RE: Transmittal of Comments – VA-18-00003 Warmenhoven Variance Transmittal of Comments

RE: VA-18-00003 Warmenhoven

SITE PLAN

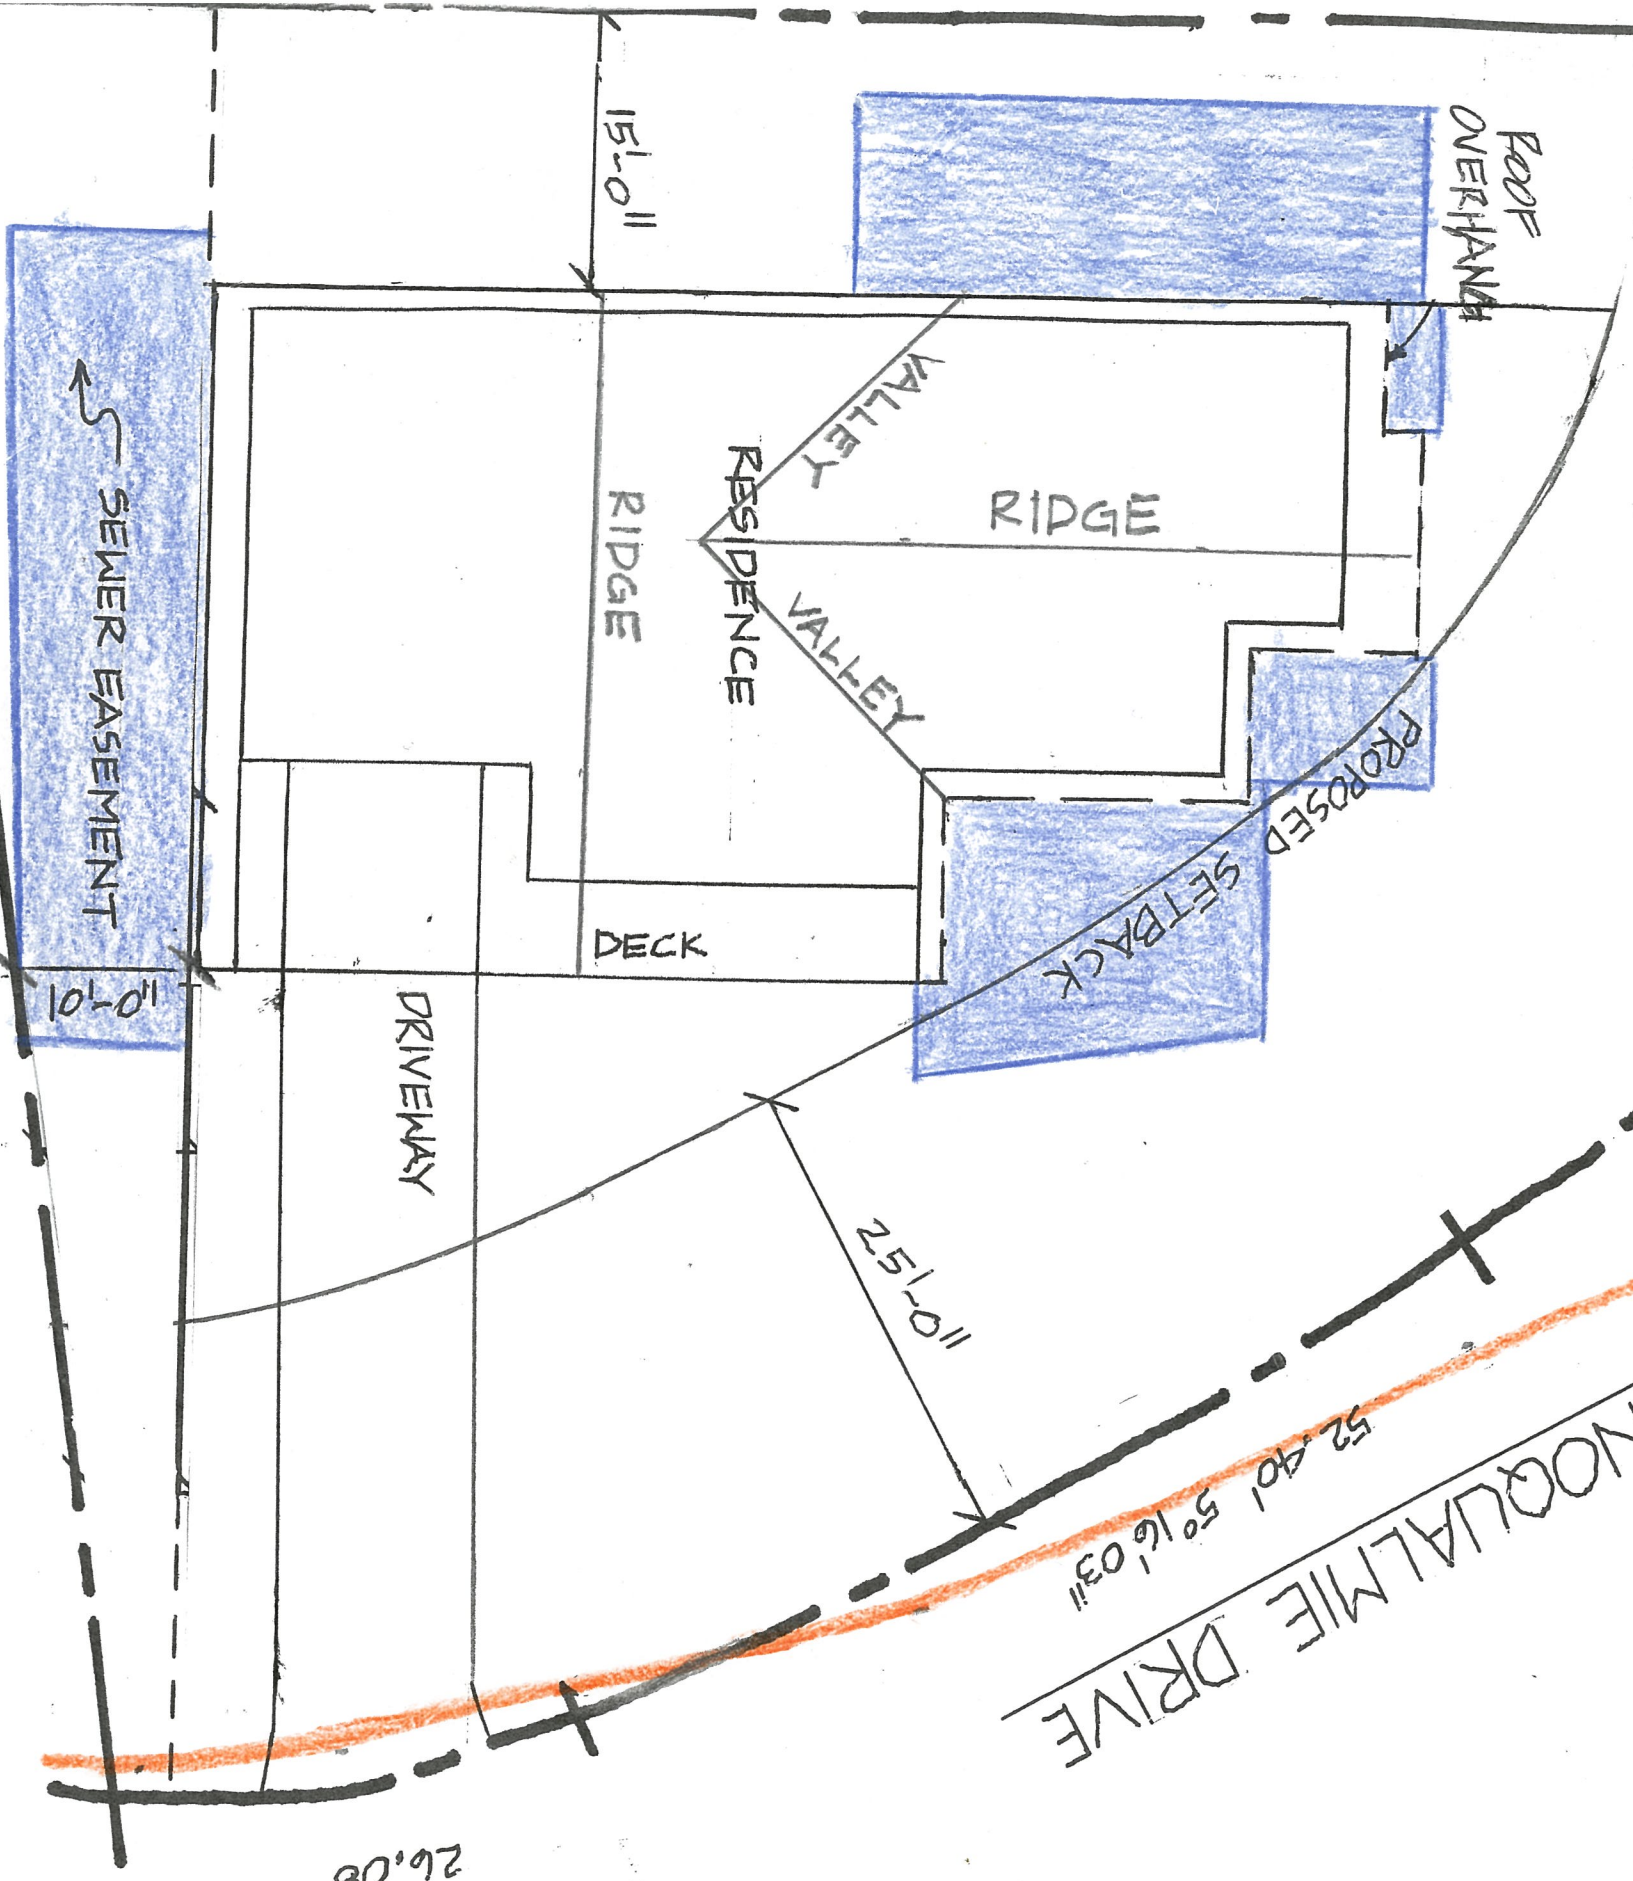
1. The fifteen foot setback requested, when in high snow load areas, can cause structural problems and disputes between neighbors (now and future) when snow continues to slide off a roof and build up on the property line. Building placement and the direction of roof pitch can all change how snow affects the neighboring property. I recommend a snow storage or removal plan be required of the architect or engineer designing the structure and added to the variance if approved.
